Ribble Valley Borough Council
Council Offices
Church Walk,
Clitheroe
Lancashire
BB7 2RA

Phone: 0300 123 6780
Email: Kathryn.Walsh@lancashire.gov.uk
Your ref: 3/2024/0687
Our ref: 3/2024/0687/HDC/KW
Date: 12 November 2024

Location: Bowland Wild Boar Park Wardsley Road Chipping PR3 2HB
Proposal: Regularisation of change of use of woodland to wedding venue, including creation of hard standing, construction of toilet block and construction of large marquee area consisting of joined and separate tipis.
Grid Ref: 365972 445114

The Local Highway Authority (LHA) are in receipt of an application for the regularisation of change of use of woodland to wedding venue, including creation of hard standing, construction of toilet block and construction of large marquee area consisting of joined and separate tipis at Bowland Wild Boar Park Wardsley Road Chipping PR3 2HB

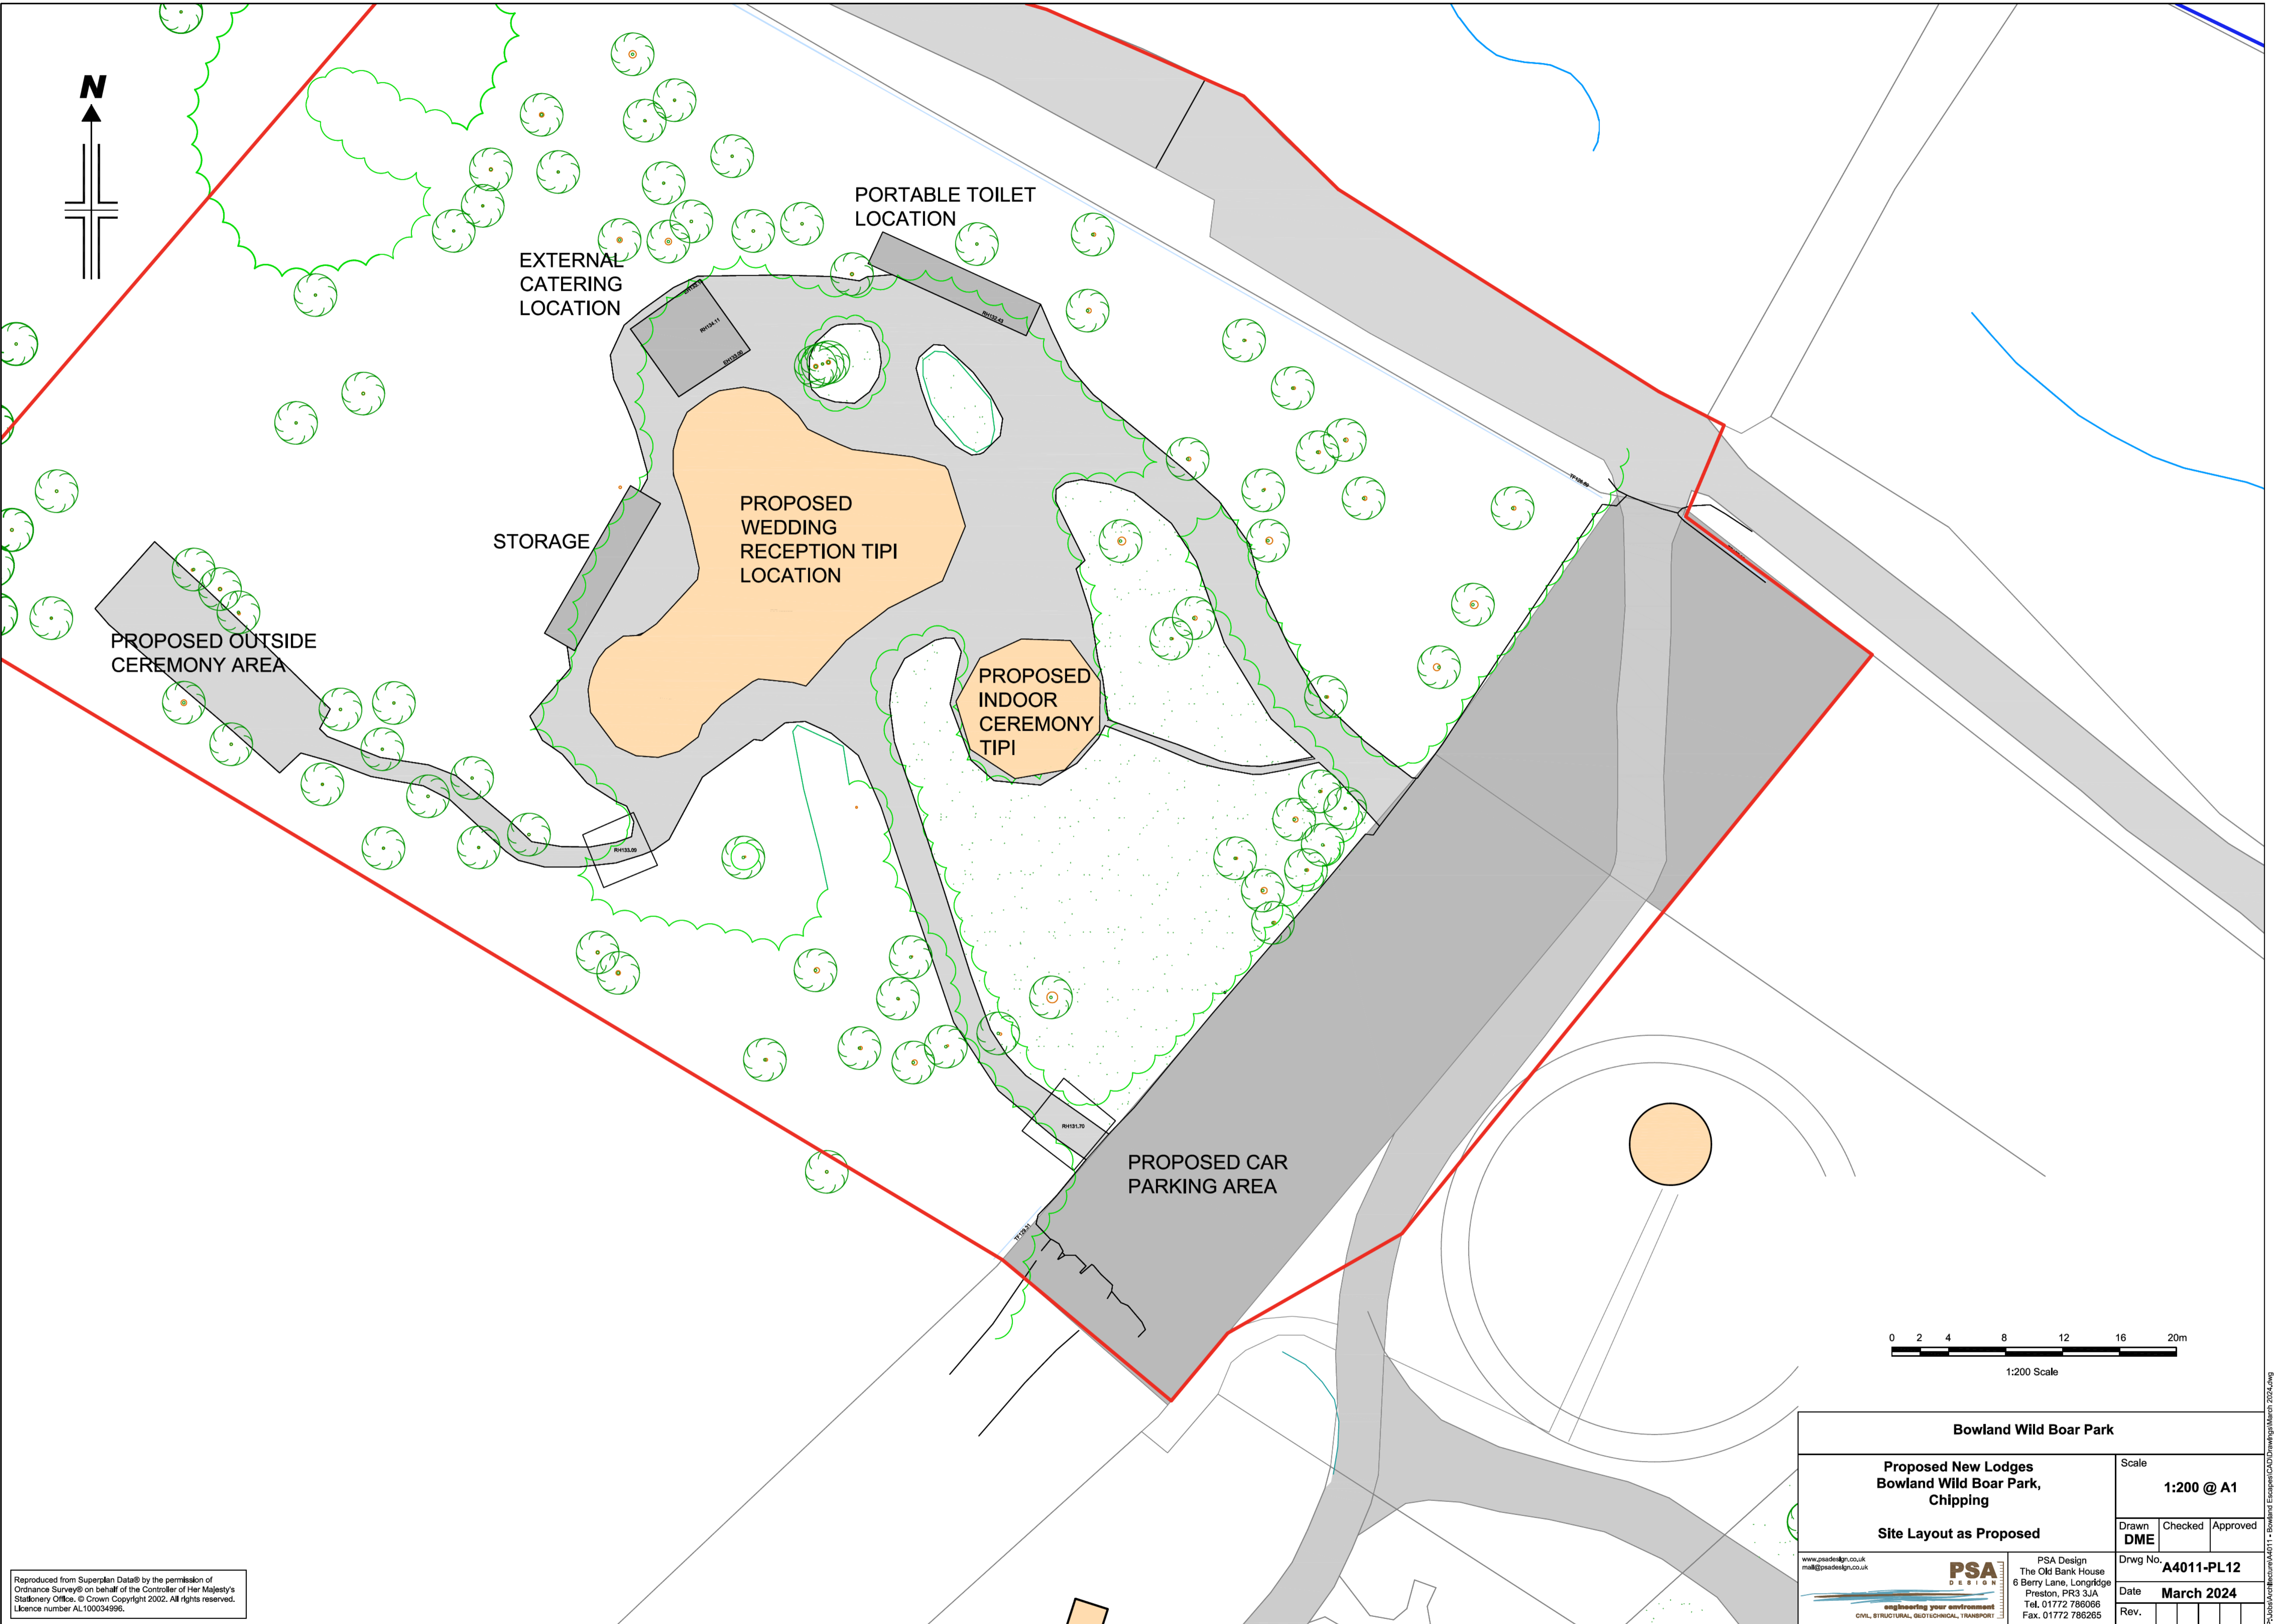
The LHA has reviewed drawing number A4011-PL12 titled Site Layout as Proposed and also note the comments made regarding parking provisions within the Transport Statement and Planning Statement. The statements advise that the venue works in partnership with Bowland Escapes and Horseshoe Glamping Executive Event Hire. The on site accommodation can cater for up to 60 guests and as explained within the transport statement each accommodation can support parking provisions. However the statements do advise that numbers from current bookings suggest around 40 guests are booked to stay on site rather than the 60 which can be accommodated. This could increase closer to the time of the event. Therefore whilst no plan has been provided showing this in practice it is expected that 40 vehicles can be accommodated for next to accommodation.

Whilst the existing car parking provisions aimed to be used for the wedding venue side of the site is shown within the plan, no detailed parking layout has been included however the application form suggests a total of 25 parking spaces can be provided. A detailed parking layout plan should include marked-out parking bays, disabled parking bays and electric vehicle charging bays. Given the nature of the site, it would be expected that all vehicles enter and exit the site in a forward gear and turning provisions are provided and shown for the largest vehicle expected to access the site.

Data collected at other venues in Lancashire, albeit in more urban settings, indicates a general ratio of 1 car per 3 guests for wedding venues. As the venue can hold up to 200 guests, this is the number the LHA will use to calculate the required parking provisions. Following this calculation the venue should provide at least 67 parking spaces. When taking into consideration the 40 parking provisions provided alongside accommodation and the 25 spaces suggested within the car parking, there is a shortfall of 2 spaces.
